Record Number: 24/00084#54

[Planning Number: SSD-50629707](#)

### The Plains Wind Farm

The Department of Planning, Housing and Infrastructure – Crown Lands has reviewed the proposal.

Figure 1: Project Layout

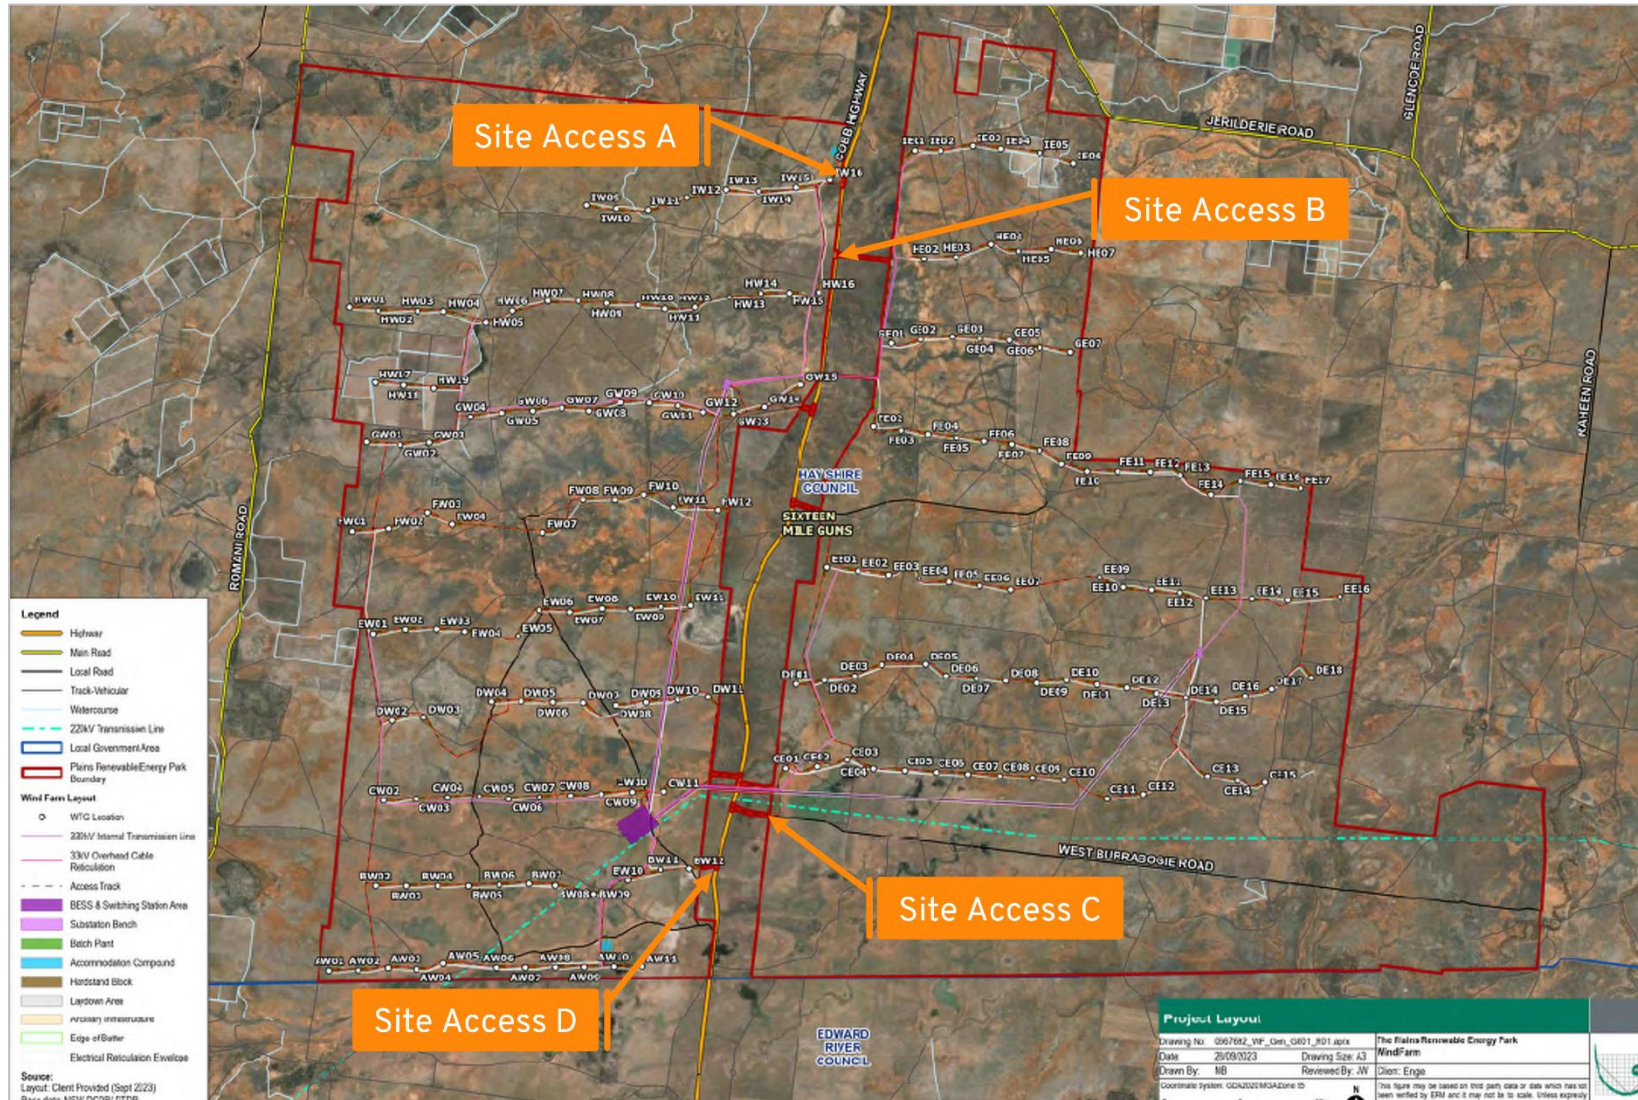
It is noted that no Crown Reserve are within the project area but there is two access roads shown on figure 2.5 Project Initial Layout, one utilising an existing access road on the eastern side of the Cobb Highway south of the 220kv Transmission Line and the other appears to be a new access road on the western side of the Cobb Highway north of the 220kv Transmission Line.

The western access road passes through Lot 7304 DP 1149704 and the eastern access road passes through Lots 7303 & 7304 DP1149704 both are Travelling Stock Reserves. These are managed by Riverina Local Land Services and is currently the subject of an undetermined Aboriginal Land Claim (ALC). As such, concurrence with the NSW Aboriginal Land Council (NSWALC) would be required.

Additionally, a tenure will be required to authorise any use of and/or access to this lot, which may be subject to Native Title. This will need to occur prior to the commencement of any works.
